**Ravensworth Composting Facility Expansion (SSD-9418)  
Response to Submissions**

## **ATTACHMENT 1**

### **Department's Comments**

<u>Name</u>	<u>Number</u>
Void 3, Stage 1 Leachate detention basin, as built plan

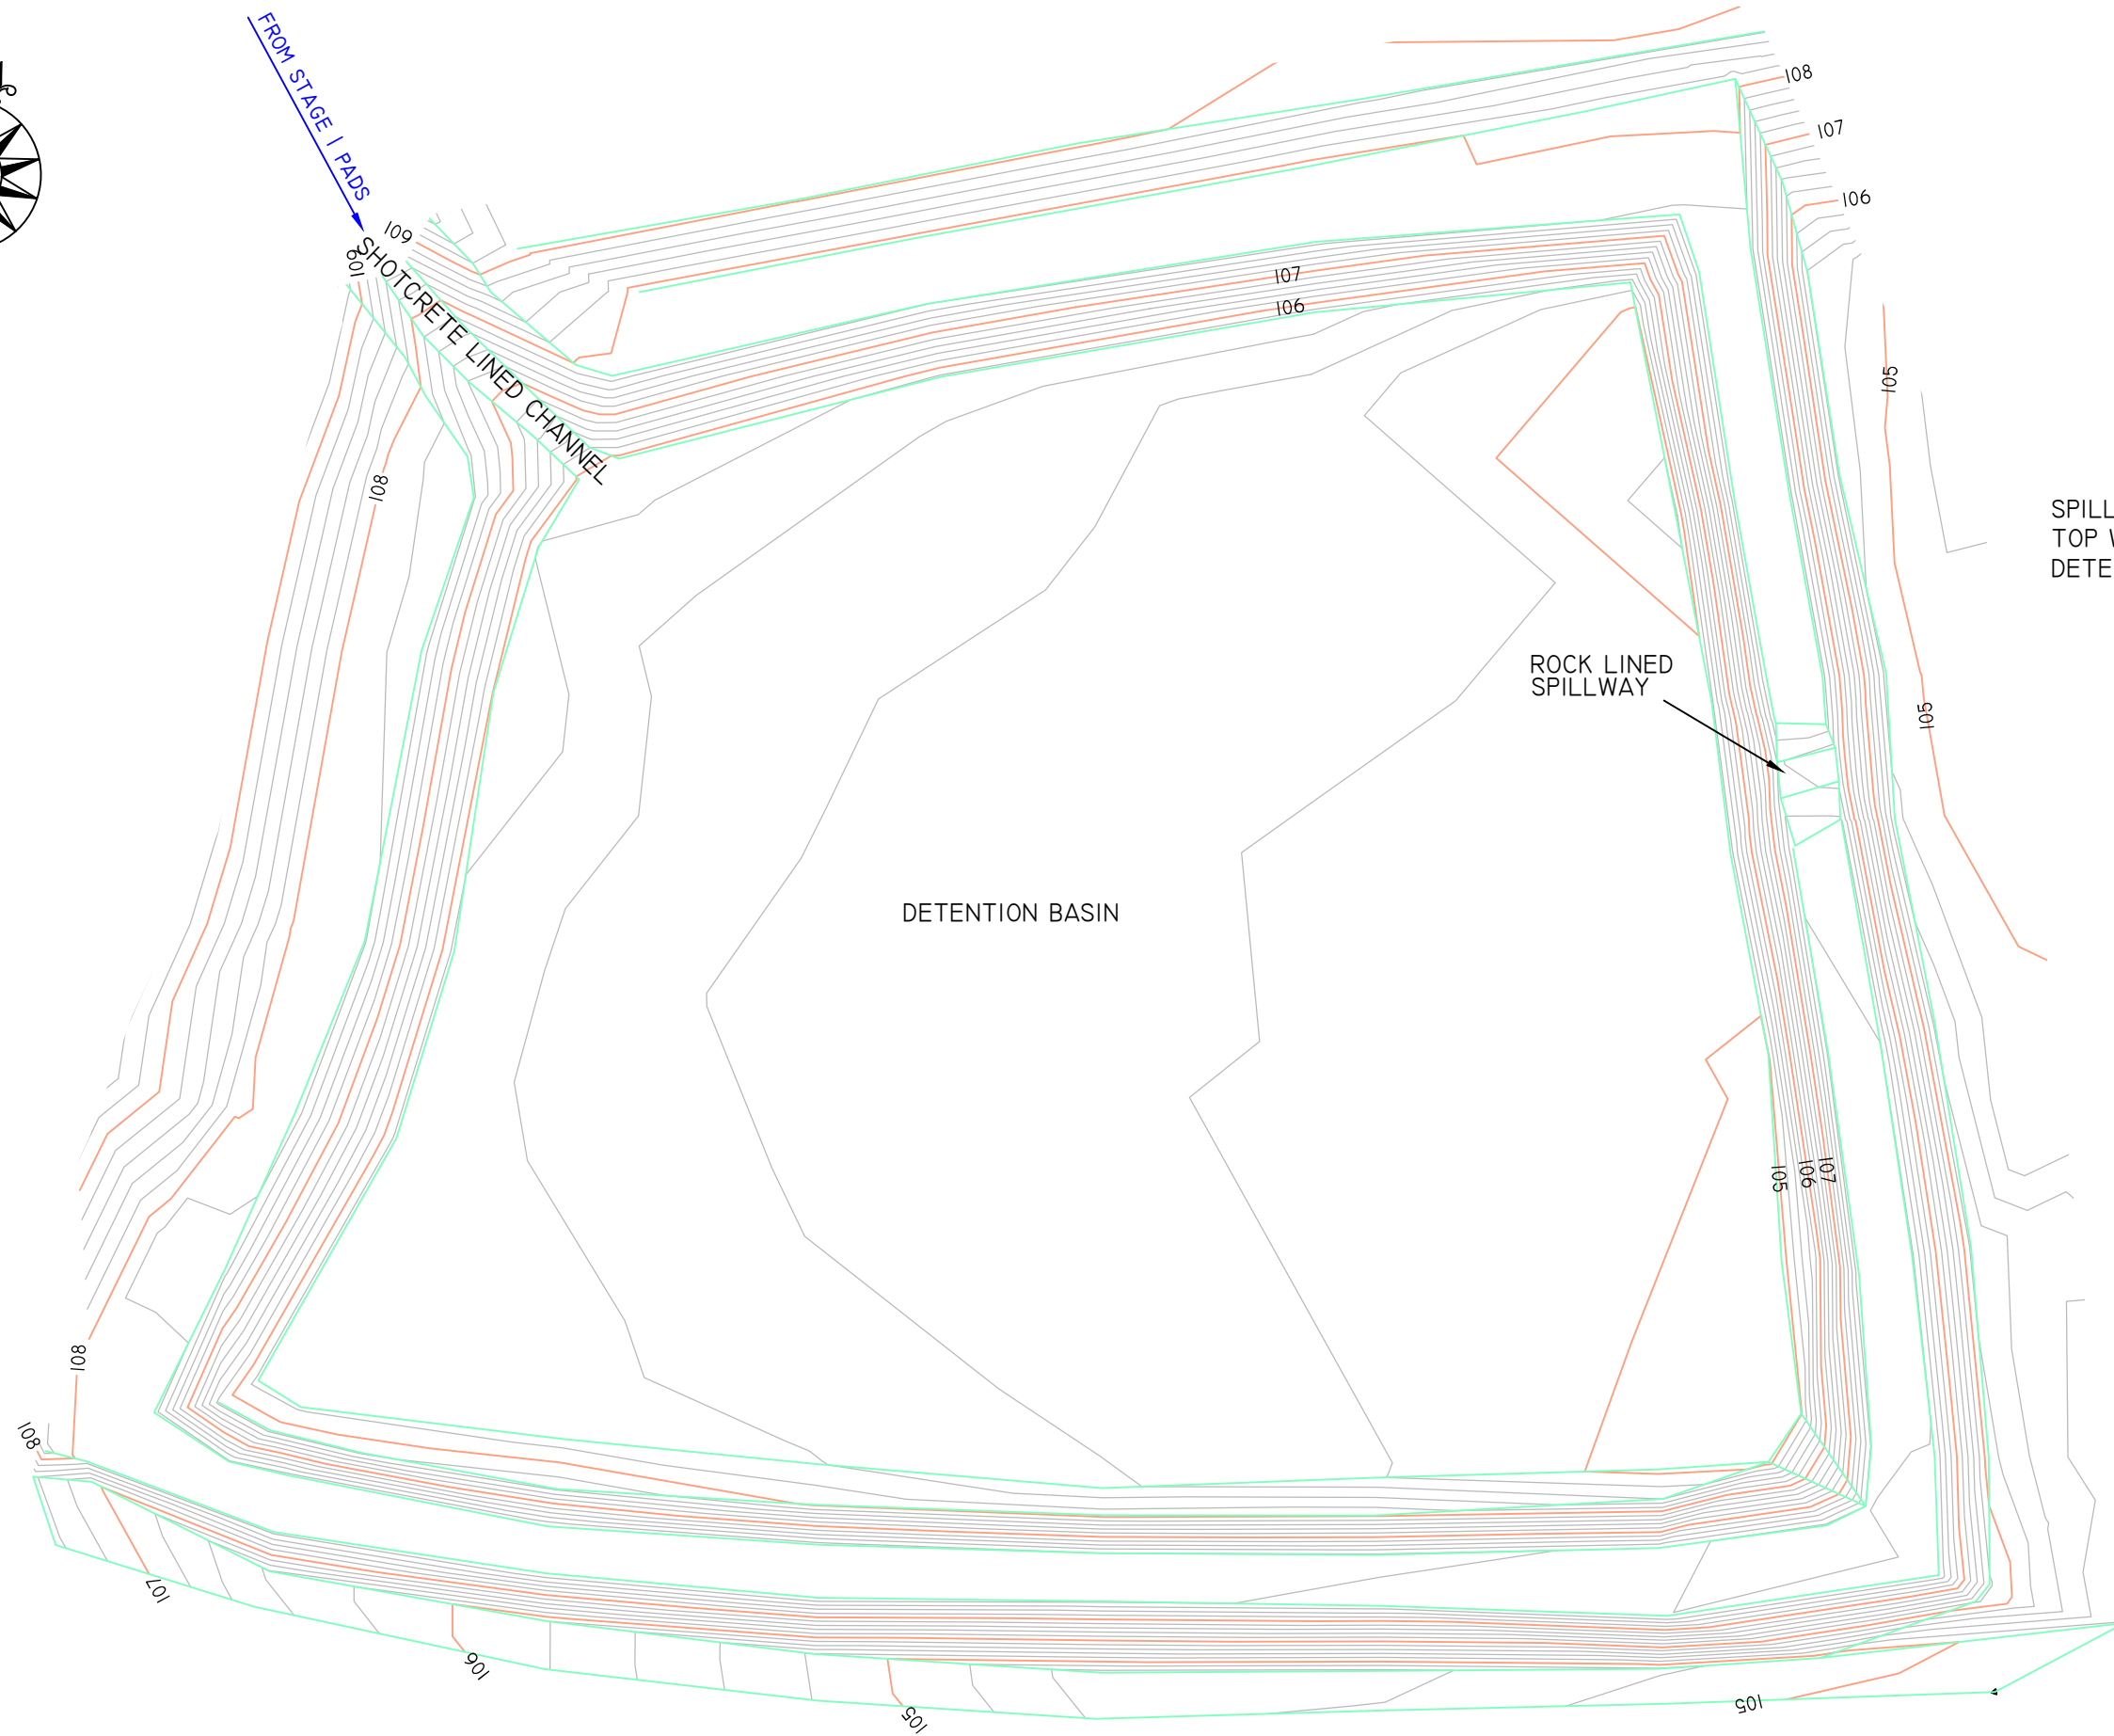
4. Specify how leachate will be treated or disposed.
5. Provide clarification on the total volume of the expanded leachate dam. Section 3.2.2.3 of the EIS states the leachate dam has been sized to provide a minimum capacity for a 1 in 25 year, 24 hour rainfall event (approx. 50 ML). However, section 3.10 of the EIS states the leachate dam will have an expanded capacity of 16 ML.
